Application No: K/2/22/HH
Site Address: 43 Golden Avenue East Preston BN16 1QX
Description of works: 2 storey front and rear extensions and alterations.

Thank you for your internet representation made on 6th February 2022 which has been recorded as no objection with the comments as follows:

Drawing: STREET SCENE/PARKING

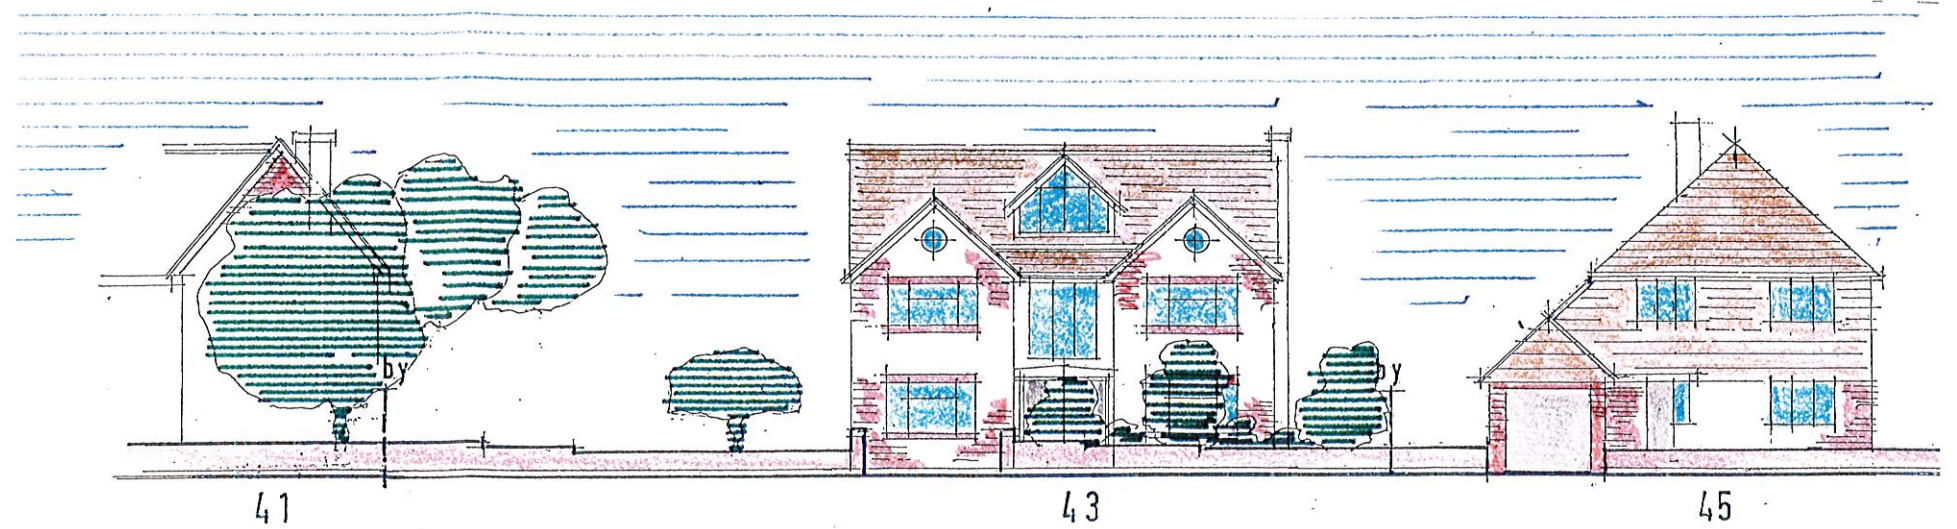
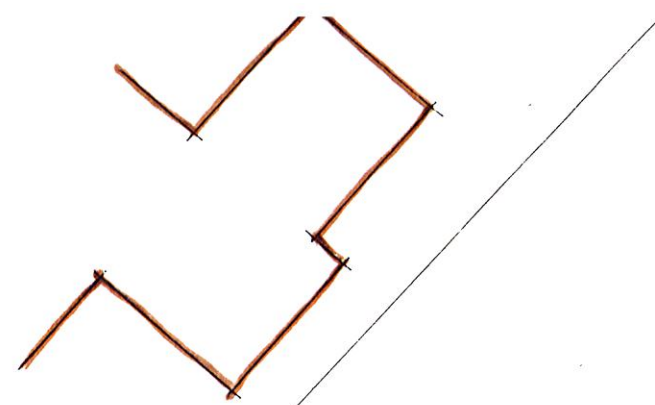
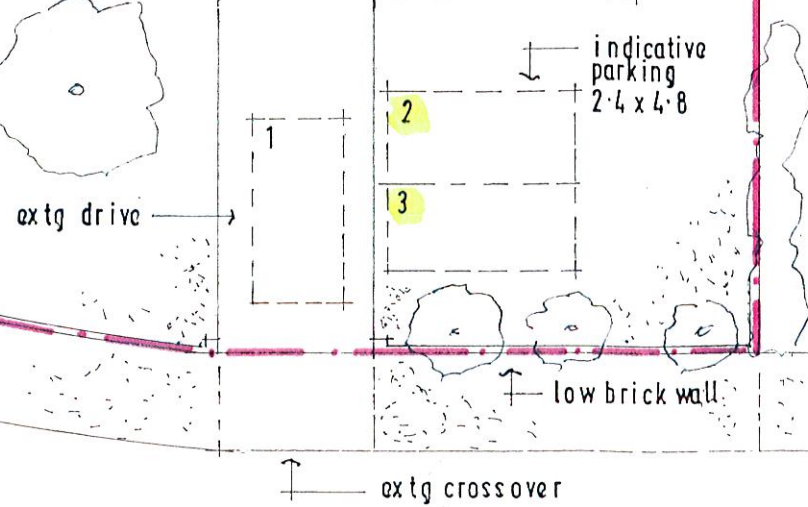
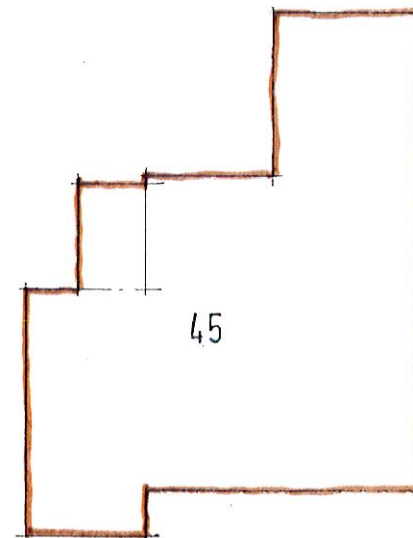
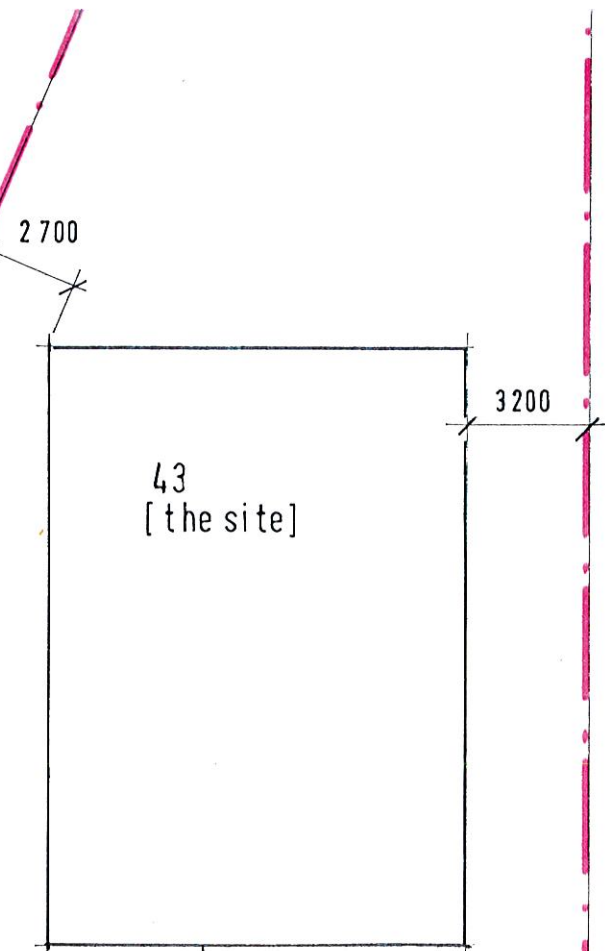
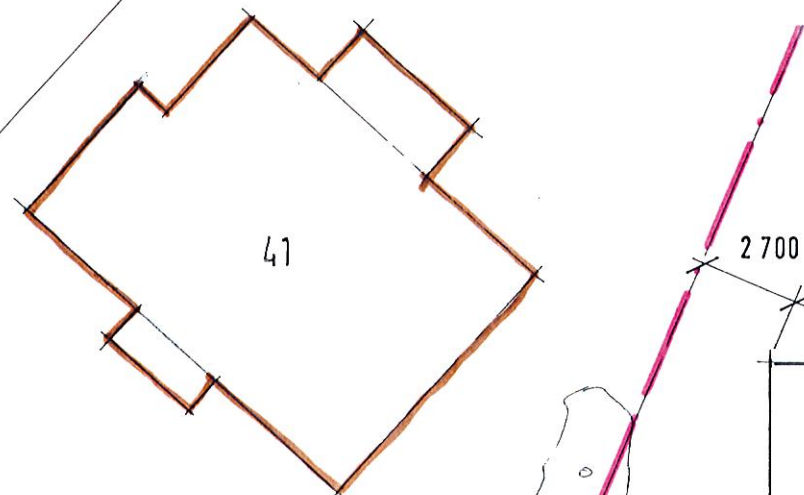
We wish to make a comment about the provision of parking as the property is so close to the bend with a double white line in front. This obviously means parking is not permitted on the road.
